CITY OF ALBUQUERQUE

Re: Weems Law Office - 108 Wellesley Dr., SE
30-Day Temporary Certificate of Occupancy- Transportation Development
Architect's Stamp dated 1-25-16 (K16-D085)
Certification dated 10-25-16

① HANDICAP PARKING SIGNS  
NTS

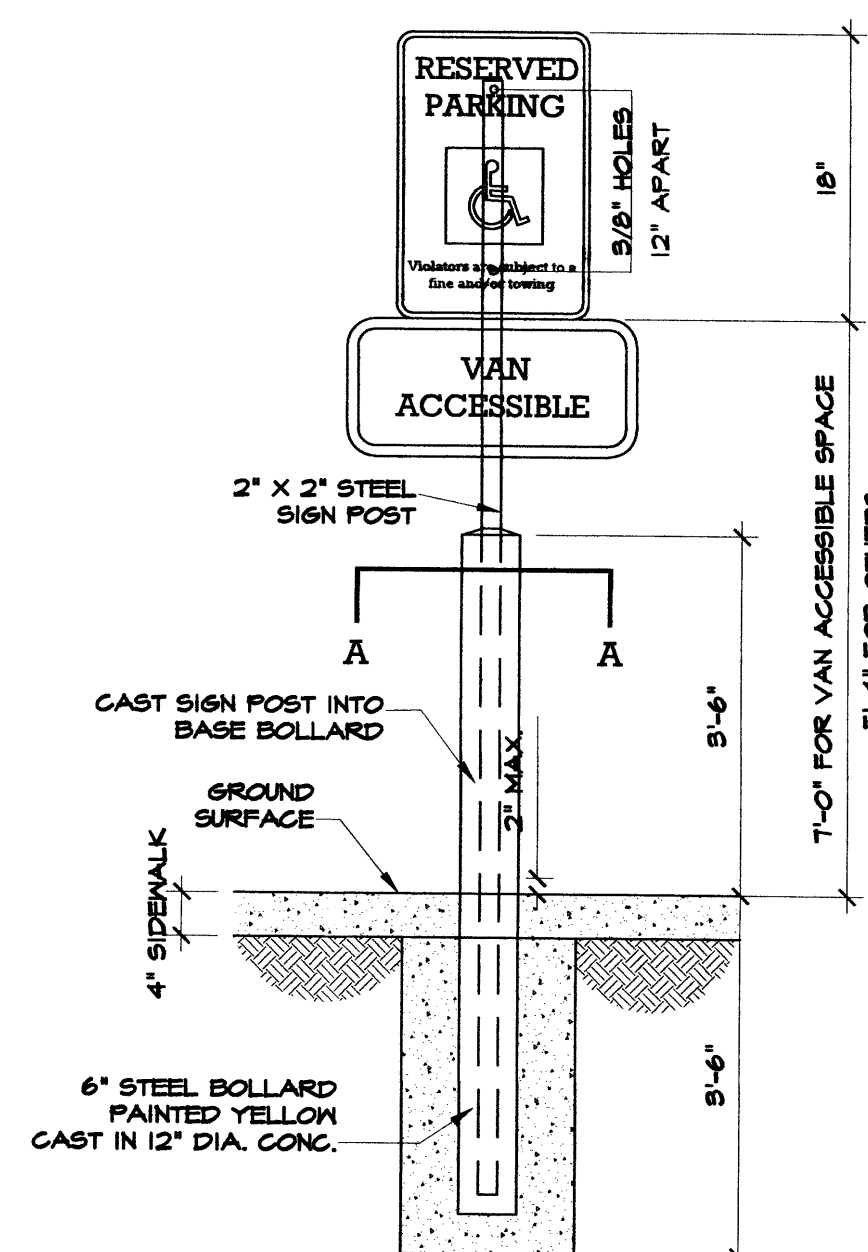
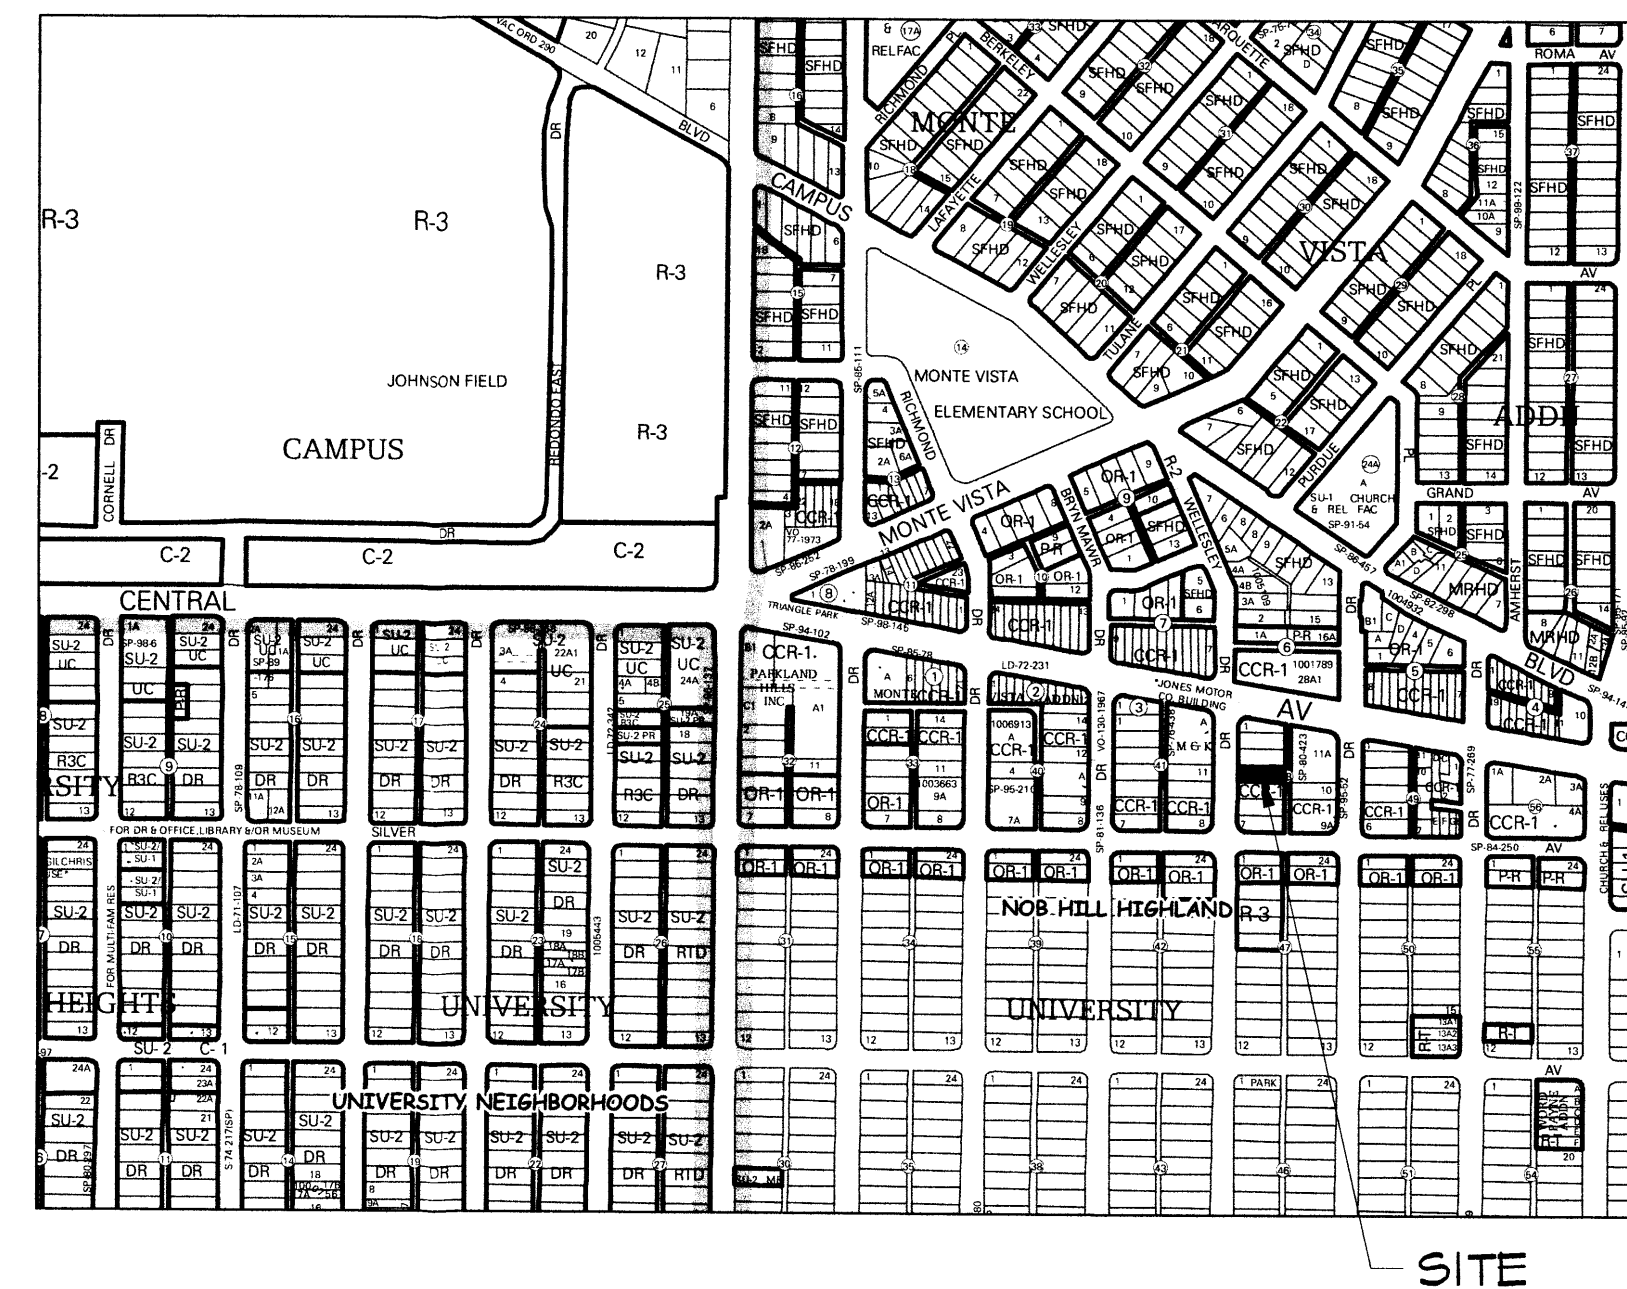
1. The ADA Van accessible parking sign is missing and must have the required language per 66-7-352.4C NMSA 1978 **"Violators Are Subject to a Fine and/or Towing."** Please call out detail and location of HC signs.
2. The ADA access aisles shall have the words **"NO PARKING"** in capital letters, each of which shall be at least one foot high and at least two inches wide, placed at the rear of the parking space so as to be close to where an adjacent vehicle's rear tire would be placed. (66-1-4.1.B NMSA 1978)
3. The ADA parking space must have a clearly visible, blue International Symbol of Accessibility painted on the pavement at the rear of the space (66-1-4.1.E NMSA 1978) or MUTCD recommends a white symbol on a blue background.
